REGULATORY ANALYSIS, SITE RISK FACTORS, ADVERSE IMPACTS FOR SENSITIVE LANDS

REQUEST FOR DISALLOWANCE OF PERMITTING FOR PROPOSED DEVELOPMENT OF SELF-STORAGE LOCATED AT 4909 JUAN TABO BLVD. (PR:2019-002184-ON-18DEC2019)

Cover Letter

From: Oso Grande Neighborhood Association (OGNA)

SITE PLAN - DRB

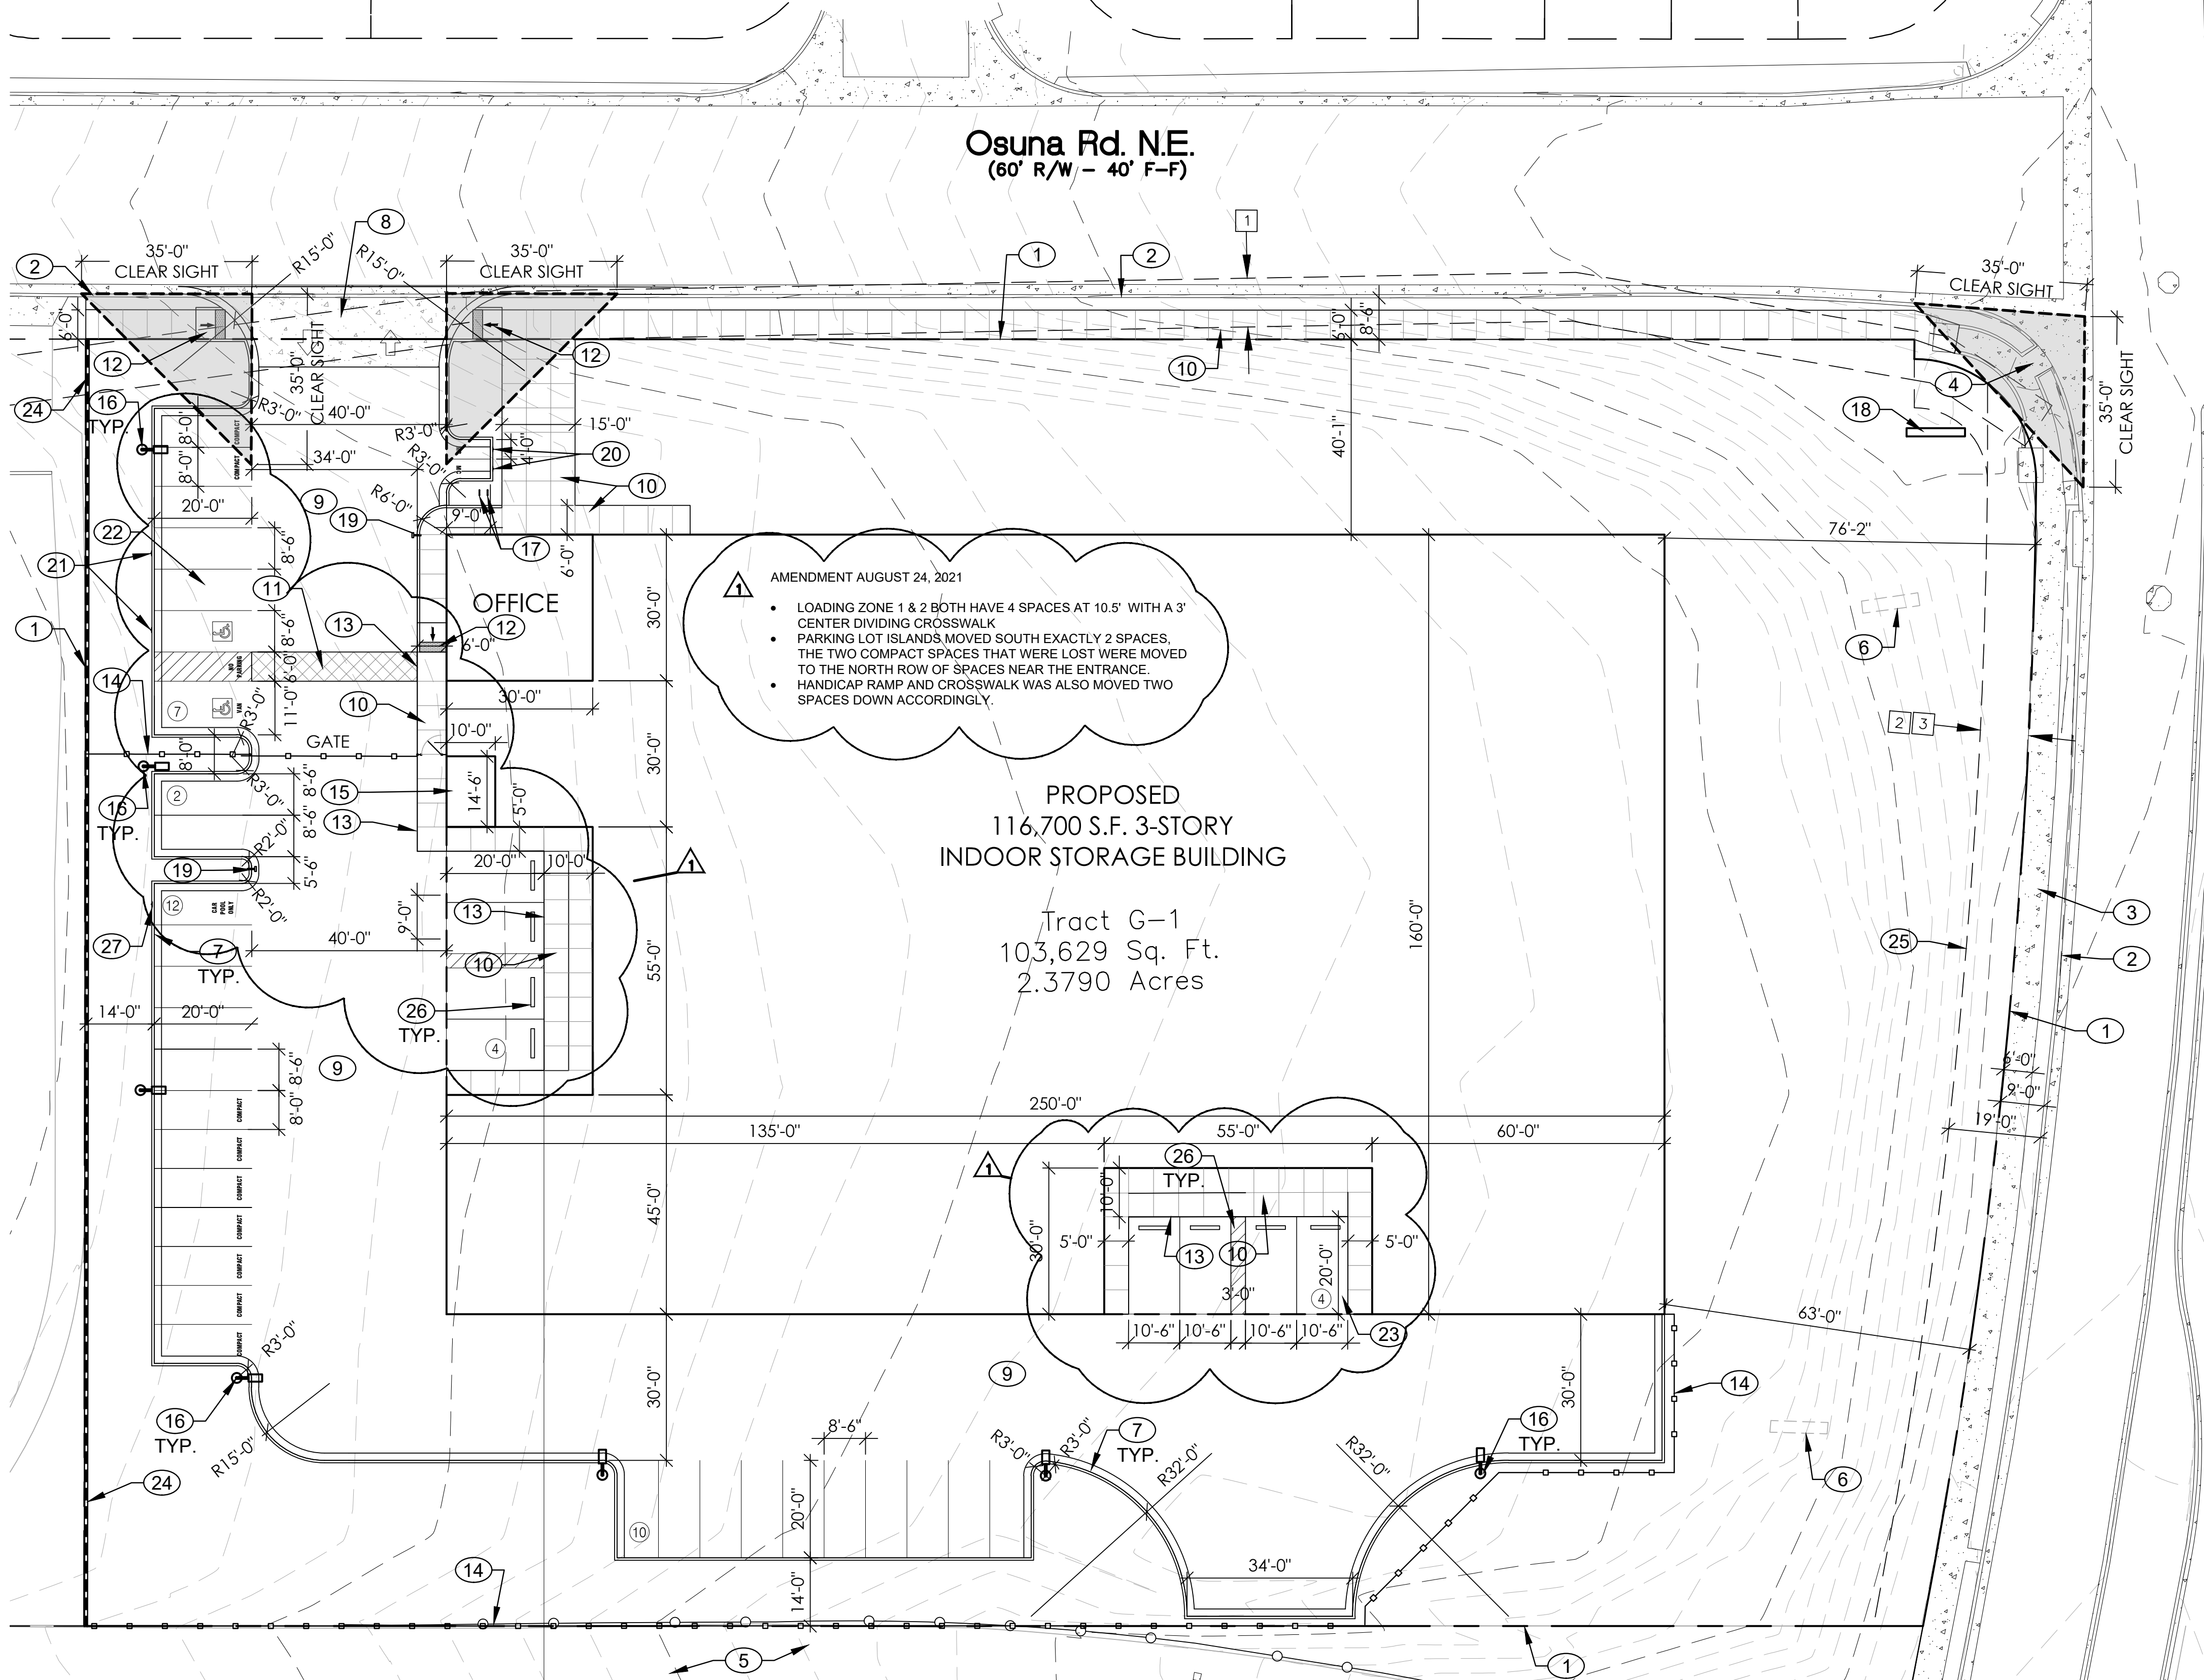
- e. When Self-Storage Becomes Warehousing. In accordance with the IDO, MX-L can be used for self-storage only, and explicitly excludes warehousing. The Site design, which was changed from the originally presented application, called for indoor storage corridors which allowed for noise suppression. The new Site Design calls for exterior loading docks with echo producing insets. This makes the structure appear as if it can be utilized more for warehousing rather than self-storage. OGNA does not consent to warehousing activity as a casually applied variance. Industrial-like operations such as warehousing defy the character of the neighborhood as residential and recreational. IDO codes are not in compliance in several areas regards site design and usage.

- i. IDO 14-16-4-3(D)(28)(e) calls for “access to storage units shall be through interior corridors”. While Site Plan may indeed call for interior corridors, the most important portion of the access, the exterior, is the noisiest part. Loading dock access on the exterior accounts for about 10% of access but is 100% of the loading noise. Site Plan defies the intent of interior corridors by utilizing exterior loading docks, hence is out-of-compliance. It suggests that much more intensive warehousing activity is planned.

- c. A Variance Between ROW on Sketch Plat for Zone Variance and ROW from Site Plan-DRB contains a 4ft. discrepancy. DRB site-plan deliberations should be based on accurate information. The four-foot discrepancy must be offset against the right of way for Osuna. Osuna which is already too narrow to accommodate large trucks. Site Design should be reworked to account for the discrepancy and shortage.

SHEET TITLE: CONCEPTUAL DRAINAGE PLAN

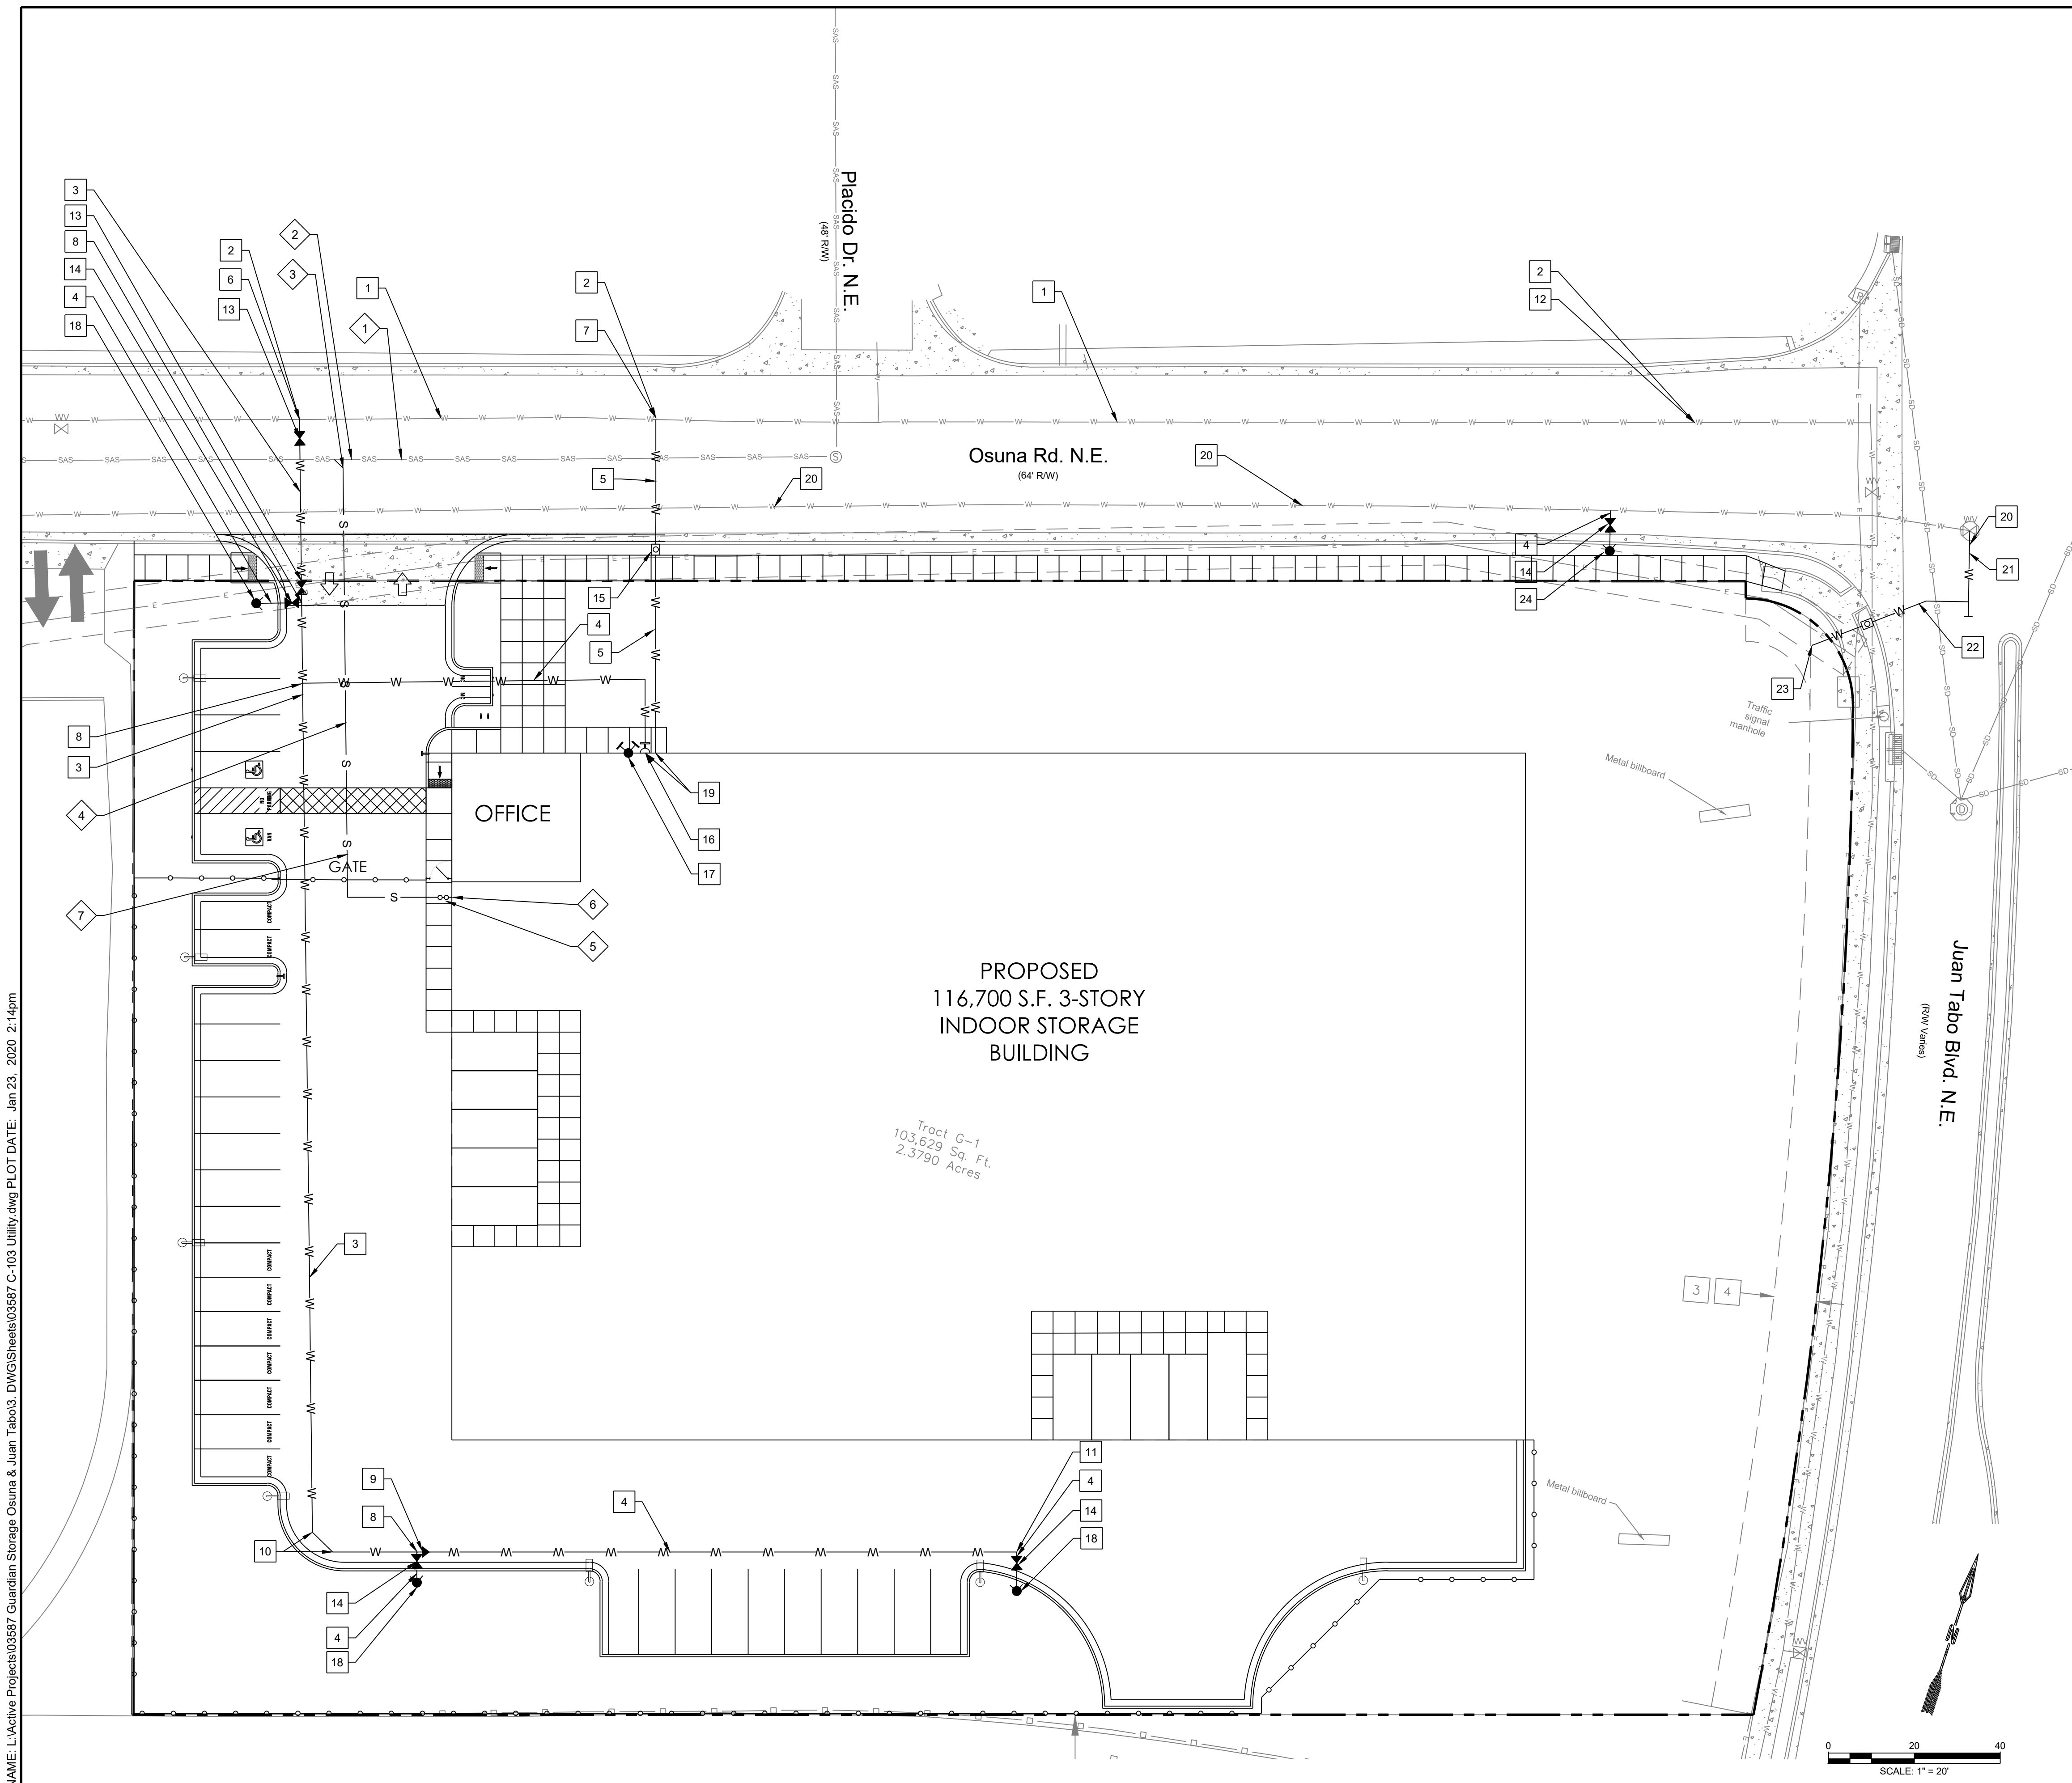
- a. Parcel east boundary is high hazard Robert Dam embankment.
 - b. increased erosion and sedimentation of all involved and adjacent infrastructure imposed by AMAFCA, federal waterway near southern boundary.

- c. Changing and variable water paths in the floodway.
 - d. greater flood volume due to removed absorption capacity introduced by storage units.
 - e. removal of catchment of dam downstream reservoir by infilling conducted by storage units.

- k. sedimentation of AMAFCA channel decreases capacity of the channel leading to greater likelihood of channel overflow.
- l. presence of dam spillway introduces non-controllable risk during heavy storm.
